From: [Jackie McDowell](#)
To: [Michel, Racquel M.](#); [Rael, Rudy E.](#); mjaramillo.2@msn.com
Cc: "[Philip & Sons Mechanic](#)"; jr.nsres@gmail.com
Subject: Site Visit Notes RE: Philip Lovato & Sons, 4101 4th St. SW- TCL (G14-D085)
Date: Friday, September 26, 2014 1:27:09 PM

Site Visit Notes:

Designed JSM	Drawn STAFF	Checked JSM	Sheet	1	of	1
File	LOV0114L	Date	FEBRUARY 2014

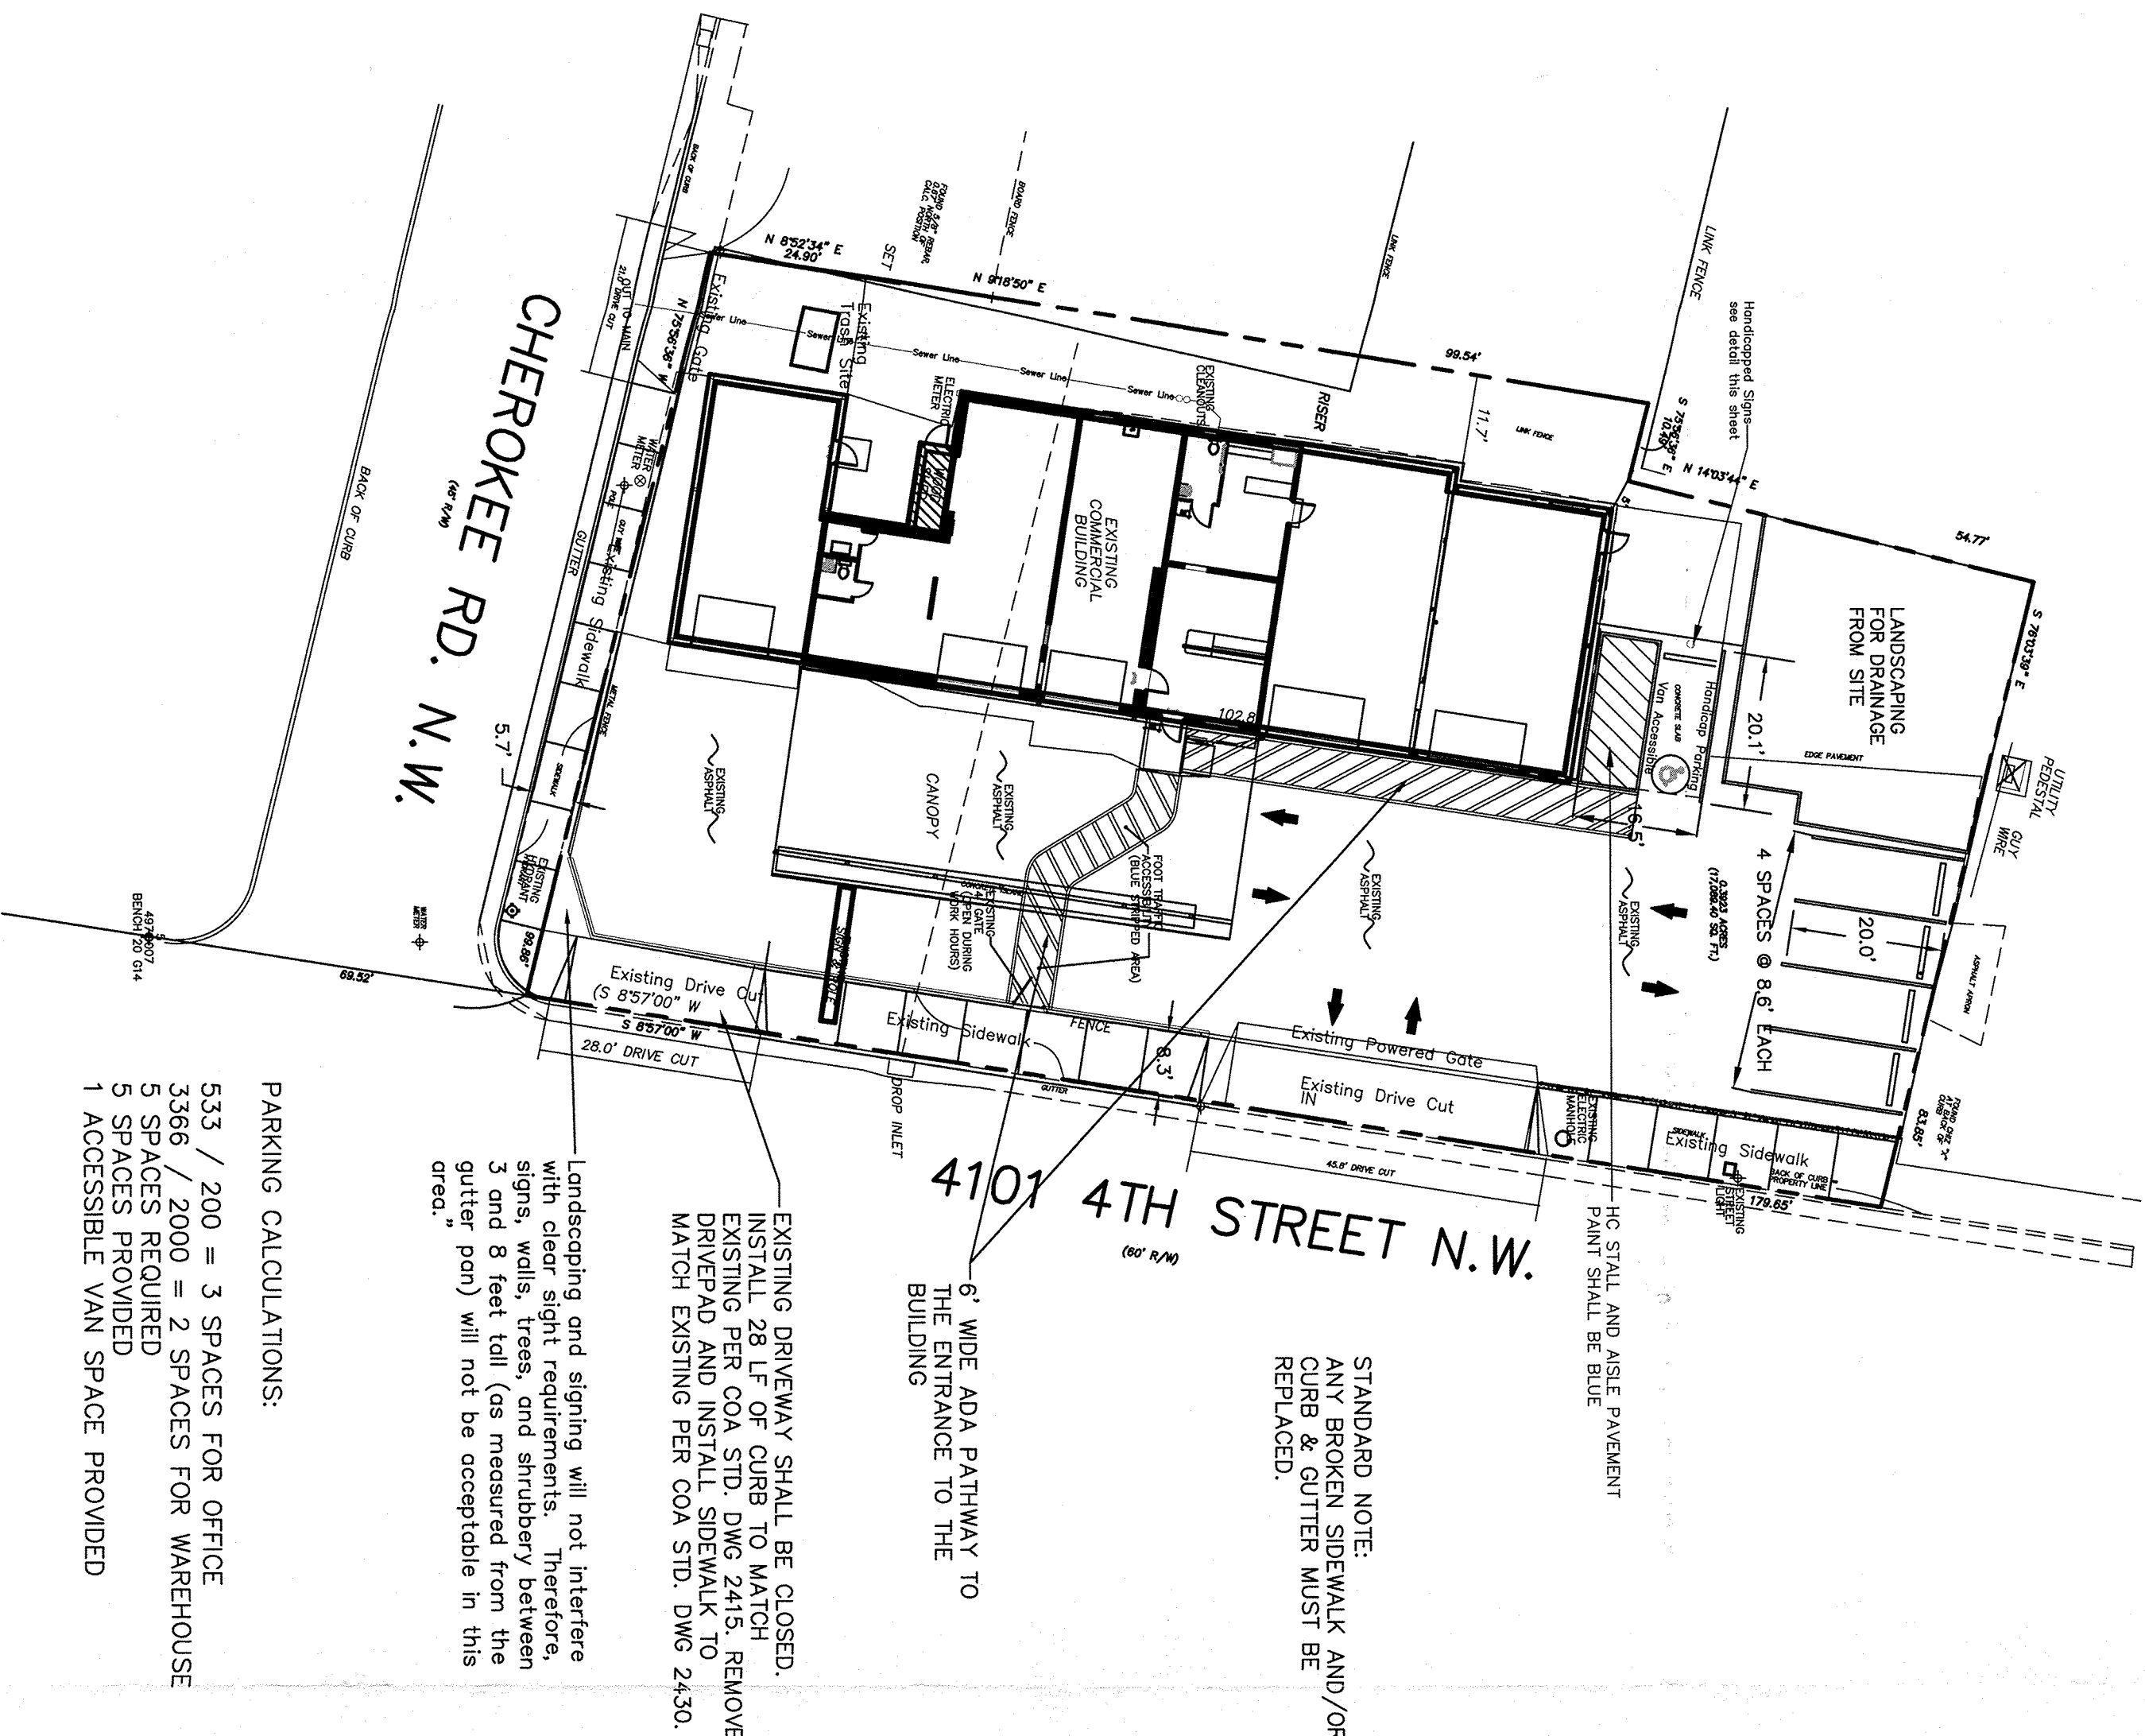
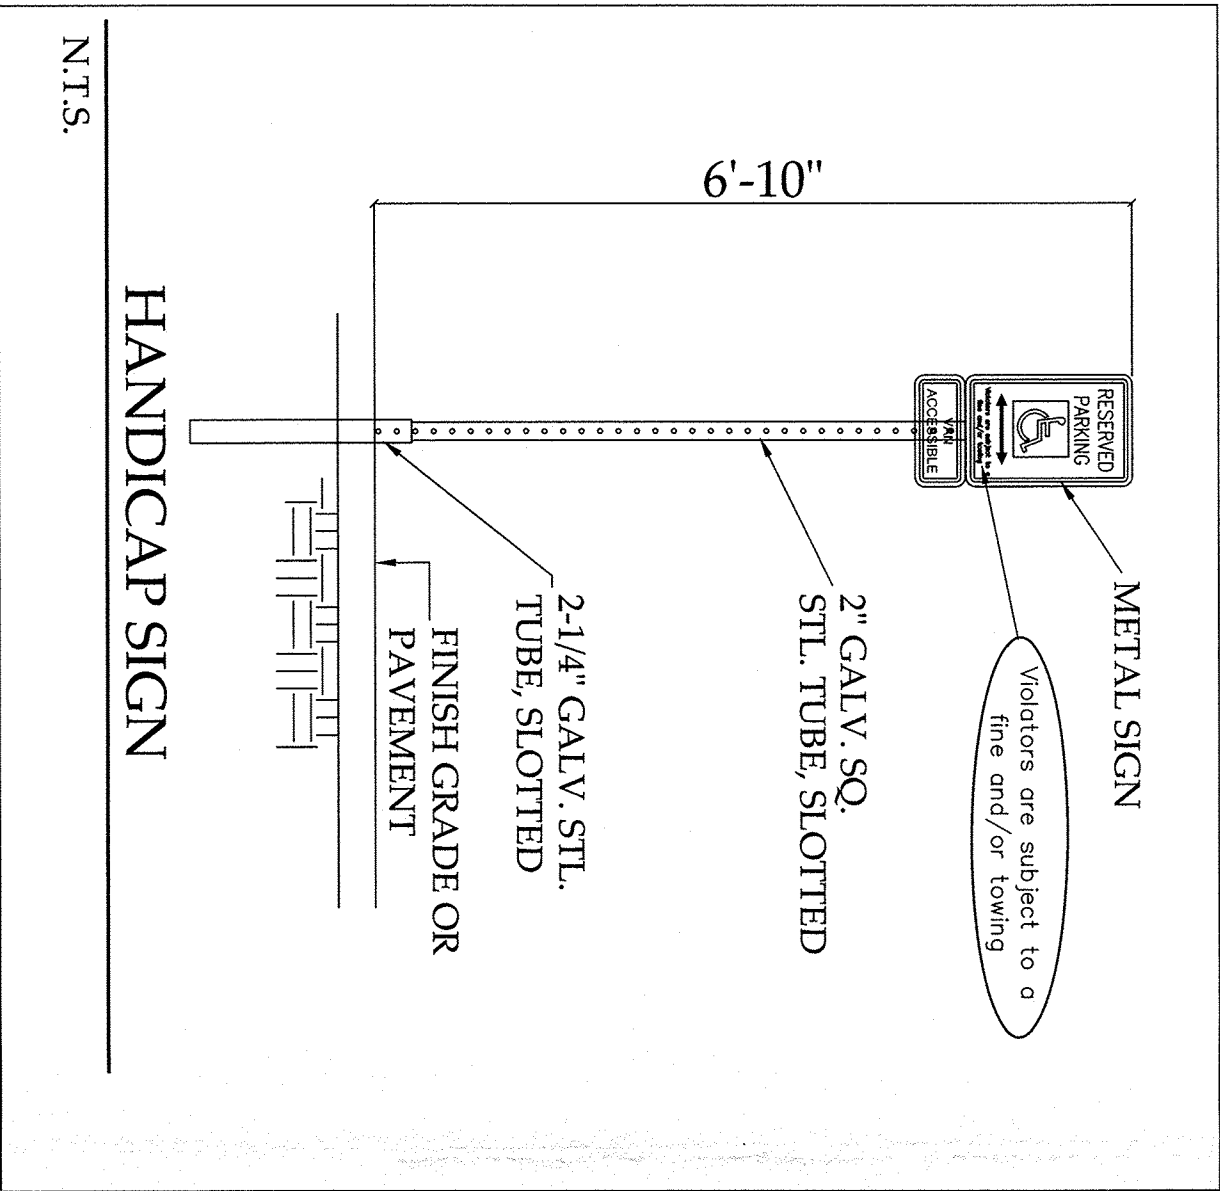
The south driveway along Fourth Street shall be replaced with sidewalk and curb & gutter. The existing bollards located at the handicap ramp at the southeast corner of the site shall be removed and truncated domes provided in accordance with city standards.
